## Application by Rosefield Energyfarm Limited for the Rosefield Solar Farm

The Examining Authority's second written questions and requests for information (ExQ2): issued on 5 June 2026

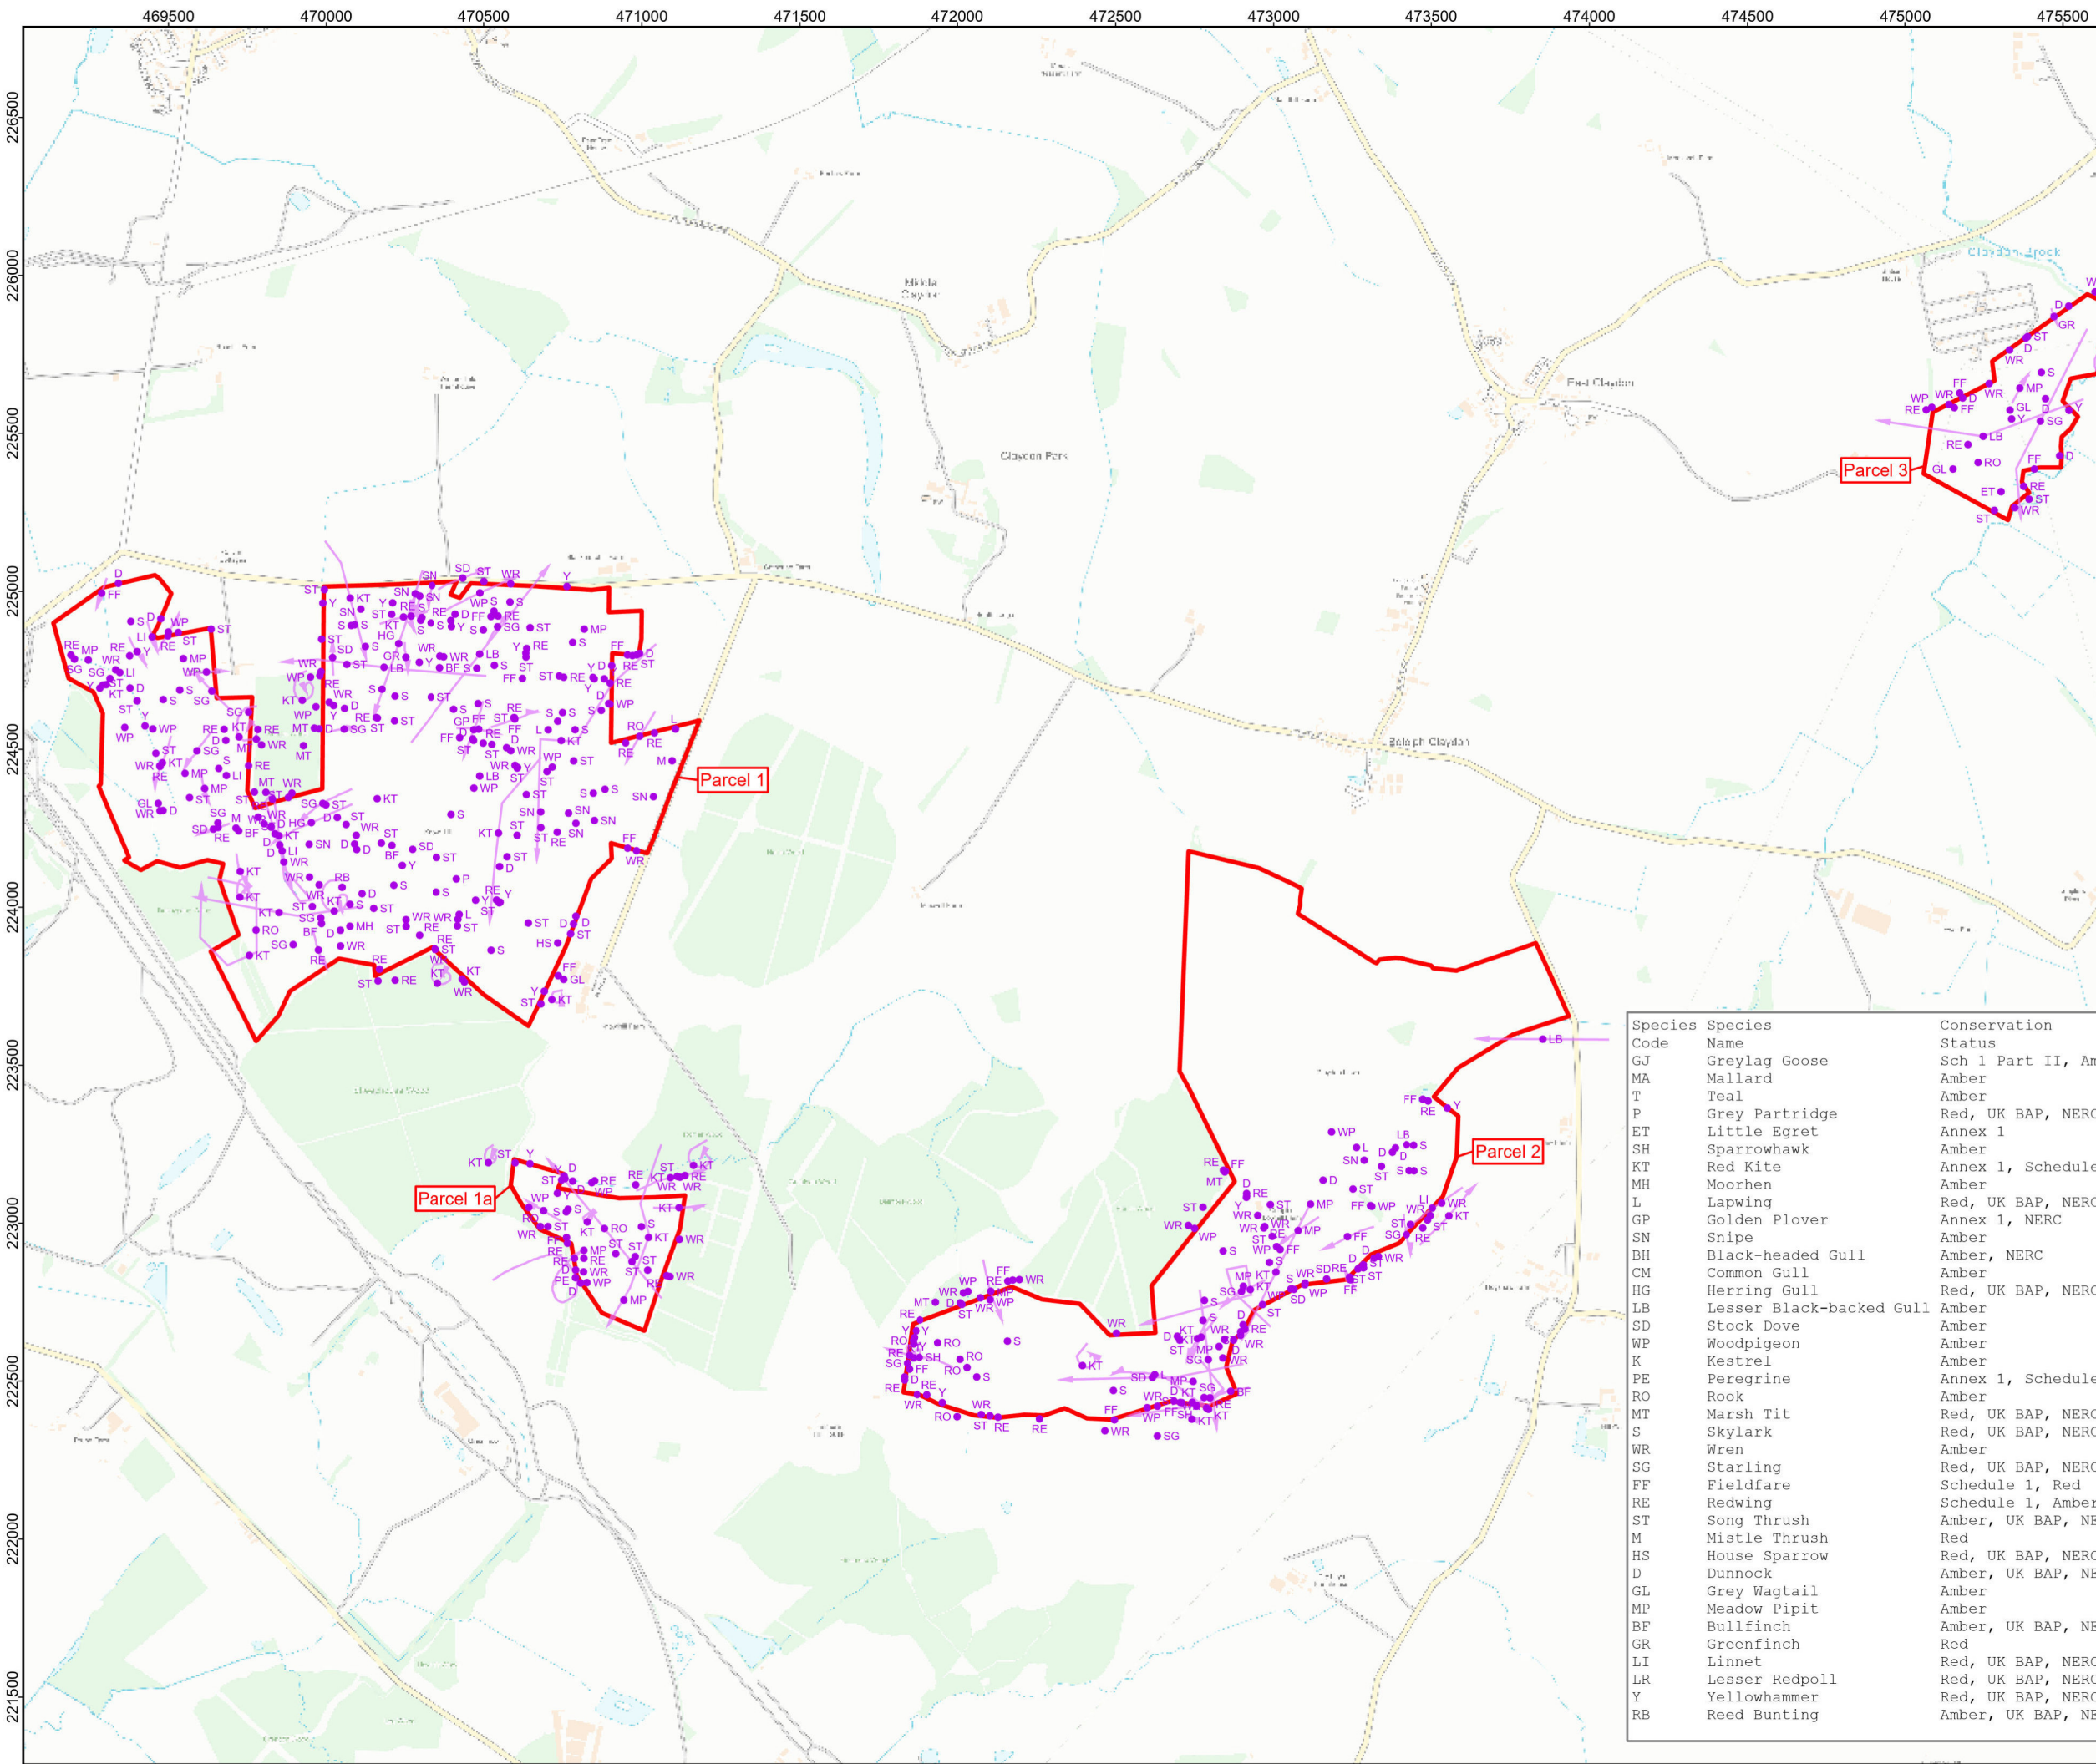
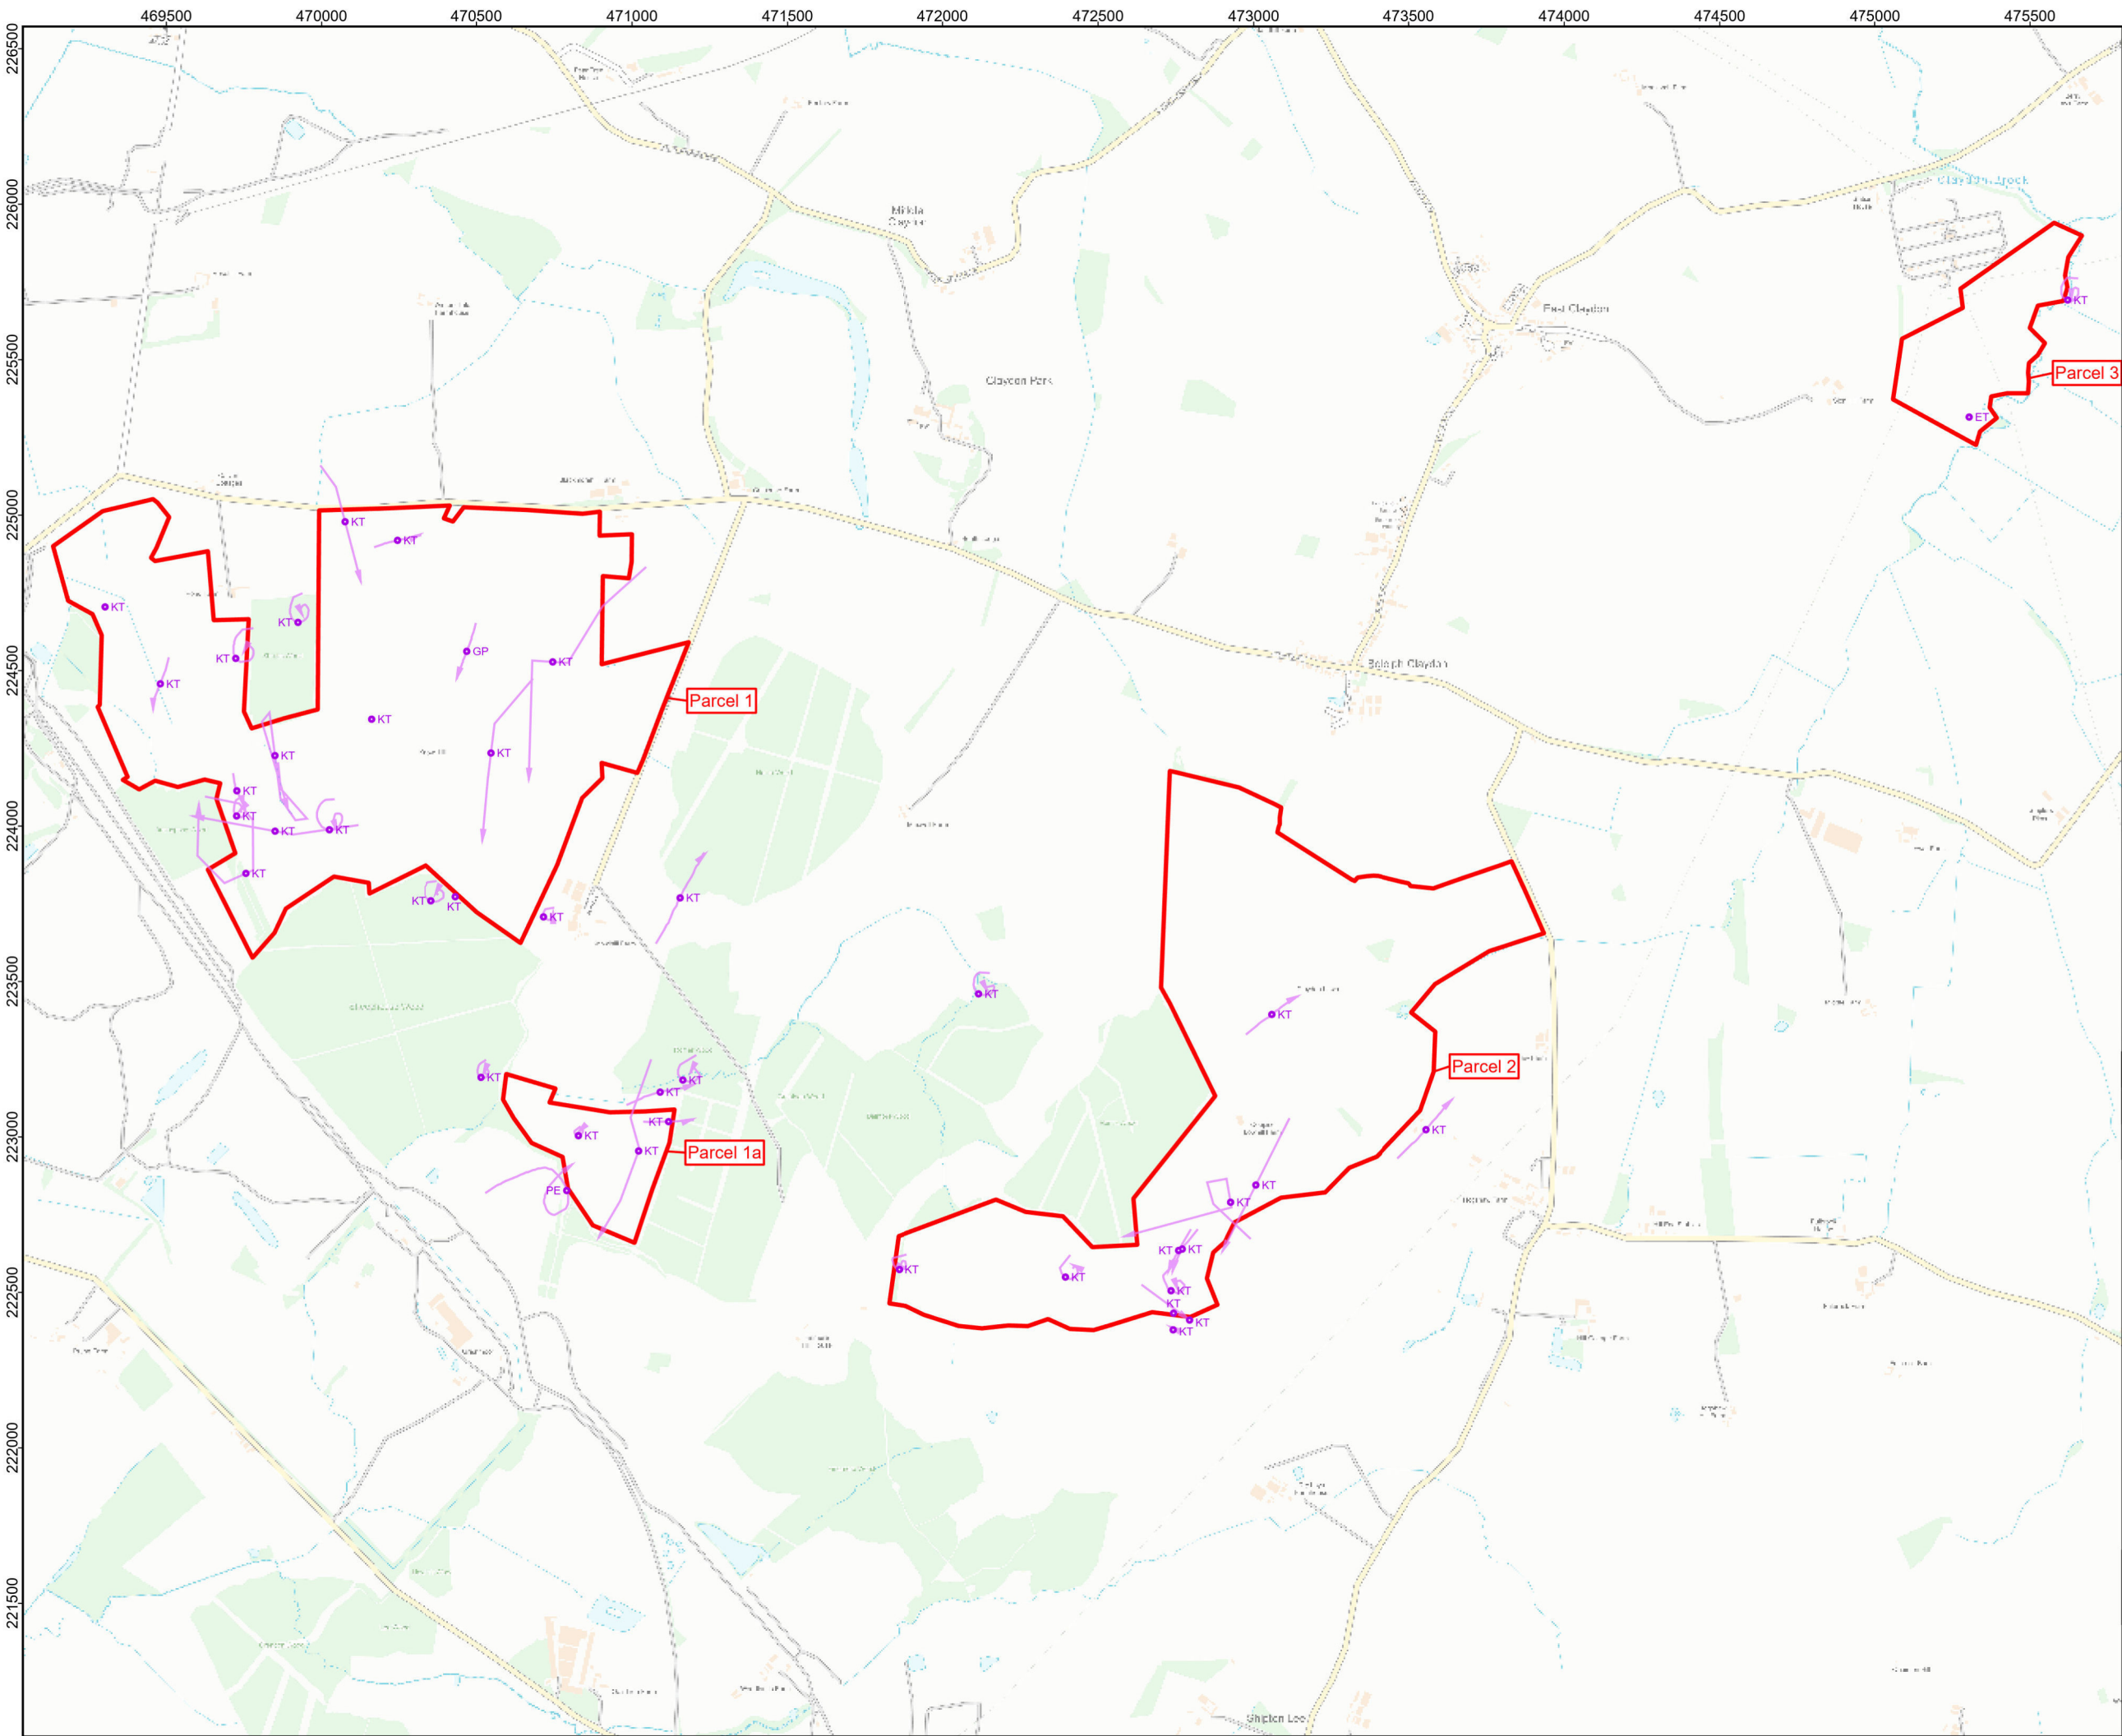
Q2.2.7	The applicant	<b>Site selection – alternatives</b> Provide further explanation for the drawing of the “site boundary” identified in the Wintering Bird Survey Report undertaken in 2022 <a href="#">[APP-089]</a> .
<b>3. Air quality</b>		
Q2.3.1	Preston Farms Limited and TCS Biosciences Limited	<b>Battery Energy Storage System (BESS) – Plume Assessment</b> Following discussions at issue specific hearing 1 (ISH1) on your critical review of the BESS Plume Assessment by a battery safety expert <a href="#">[REP2-107]</a> the applicant has updated its BESS Plume Assessment Summary <a href="#">[REP3-042]</a> and included commitment D25 in its Design Commitments <a href="#">[REP3-010]</a> “BESS containers and transformer units will be offset at least 50m from the southern boundaries of fields D8 and D9 and the eastern boundary of field D9  Has this addressed all your concerns? If not, what further action should the applicant take?
